Your ref:	21 Queens Grove, St Johns Woo...	<b>Please reply to:</b>	<b>Rayhan Ali</b>
Our ref:	21/07019/FULL	Tel No:	07866033247
		Fee Queries:	0207 641 6500;
		Email:	planningreception@westminster.gov.uk;
George Esdaile Clague 62 Burgate Canterbury CT1 2BH United Kingdom		<b>Incomplete Applications</b> Development Planning City of Westminster PO Box 732 Redhill, RH1 9FL	
		20 October 2021

**Address: 21 Queen's Grove, London, NW8 6EL,**

**Proposal: Replacement of windows including landscaping to the front and rear garden areas. Installation of new bin and bike store with associated internal alterations. (Linked with 21/07020/LBC)**

Drawing Description
Proposed Bike and Bin Store
Plan and Elevations

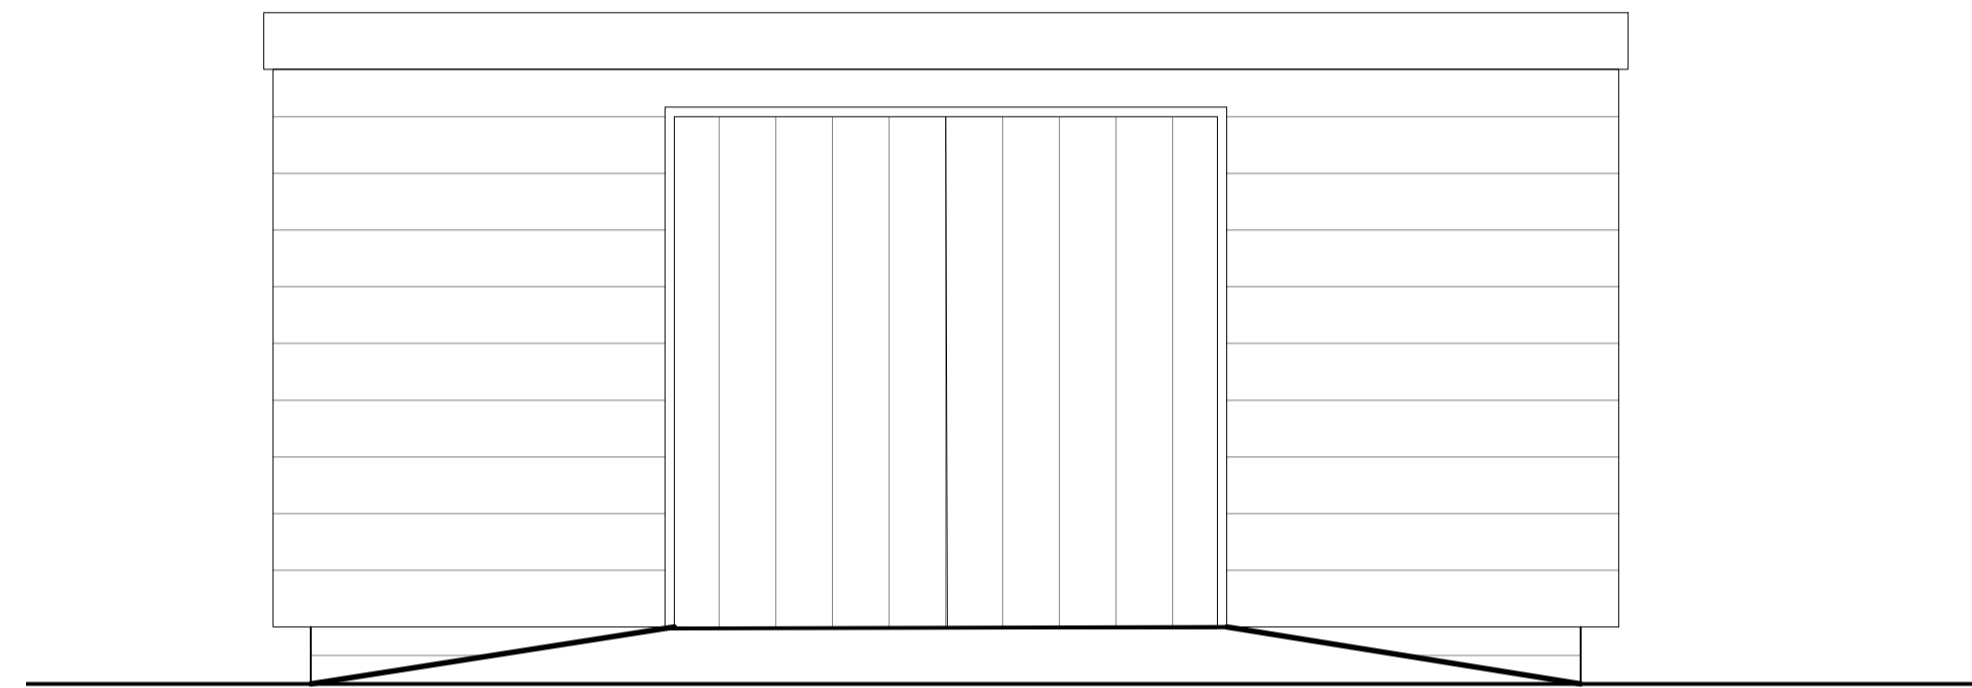
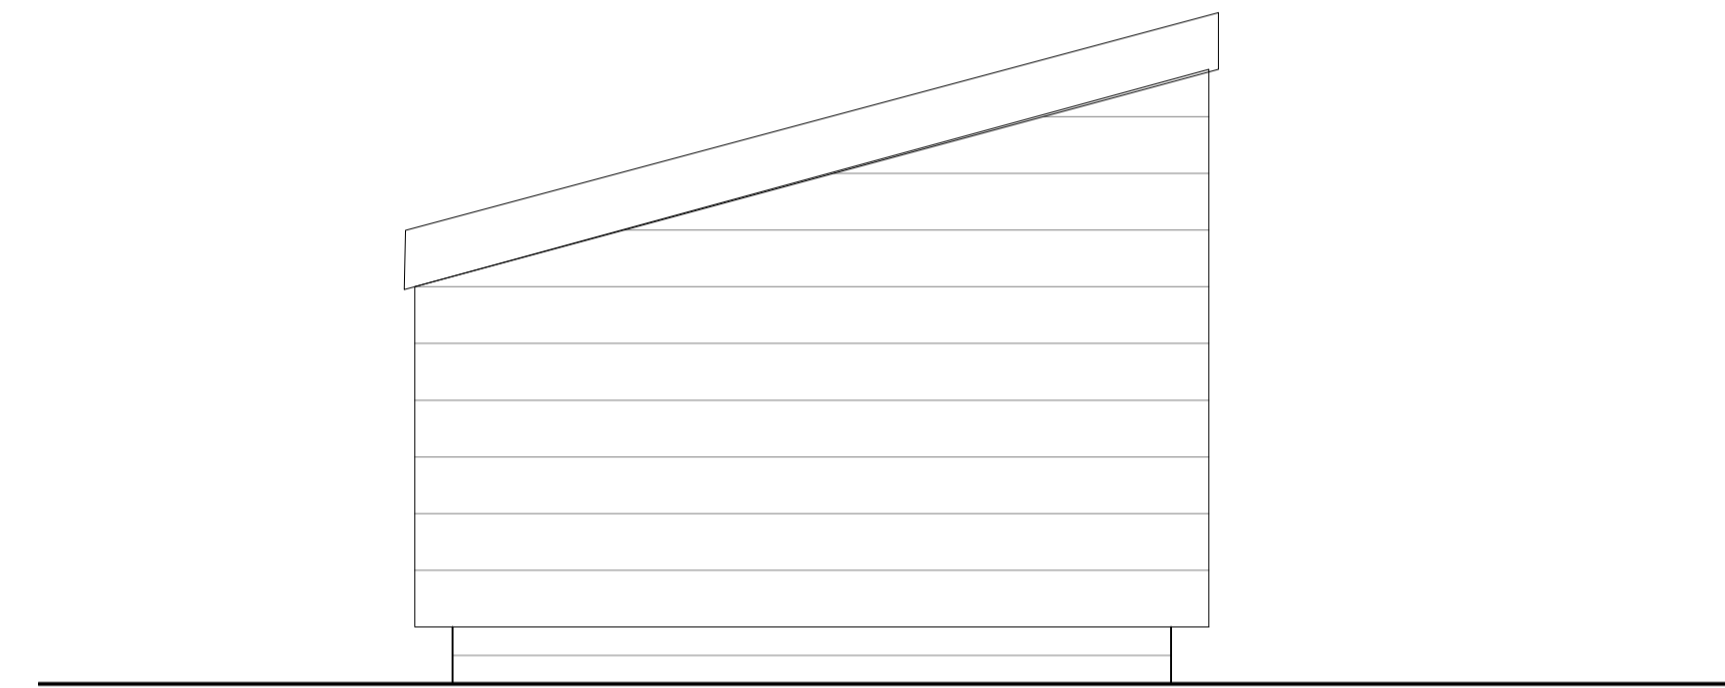
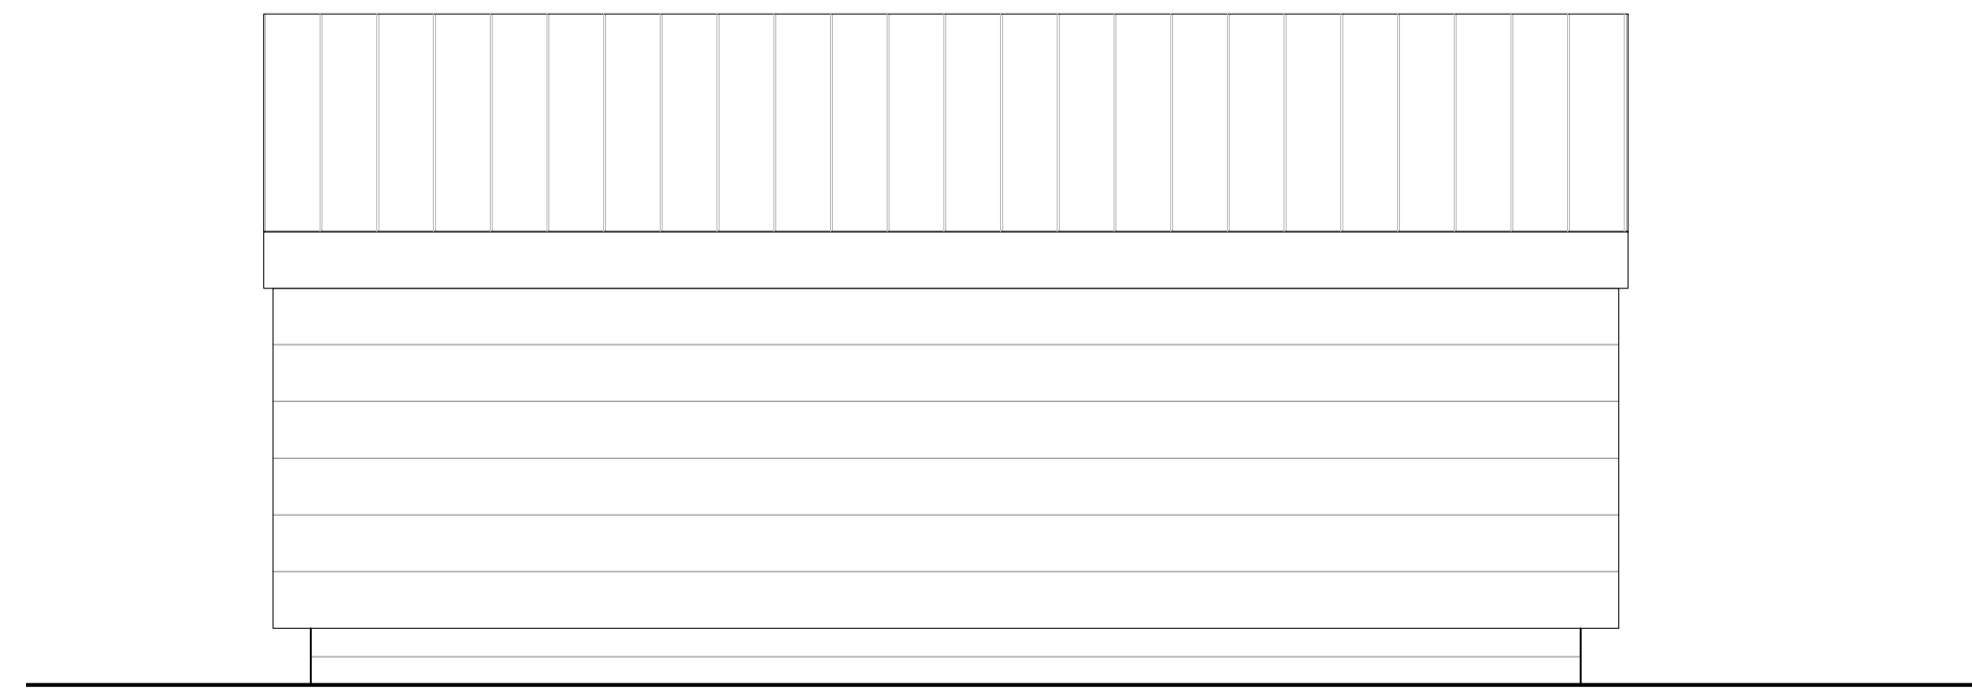
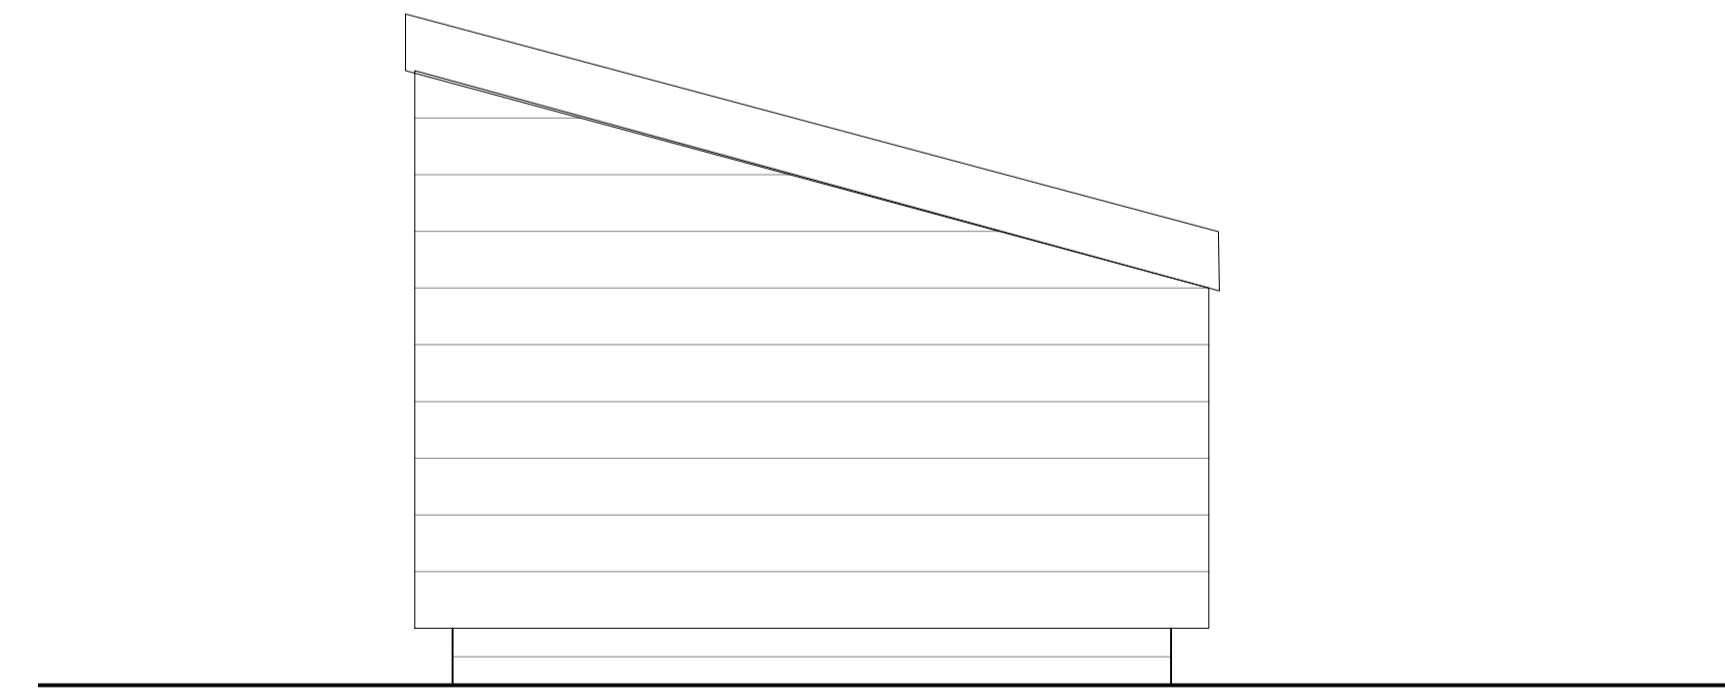
- 1 Plans show air con units on the roof. These are not discussed within the D&A or heritage statement.
- 2 Bike store not shown on teh proposed drawings
- 3 Please submit a detailed acoustic report.
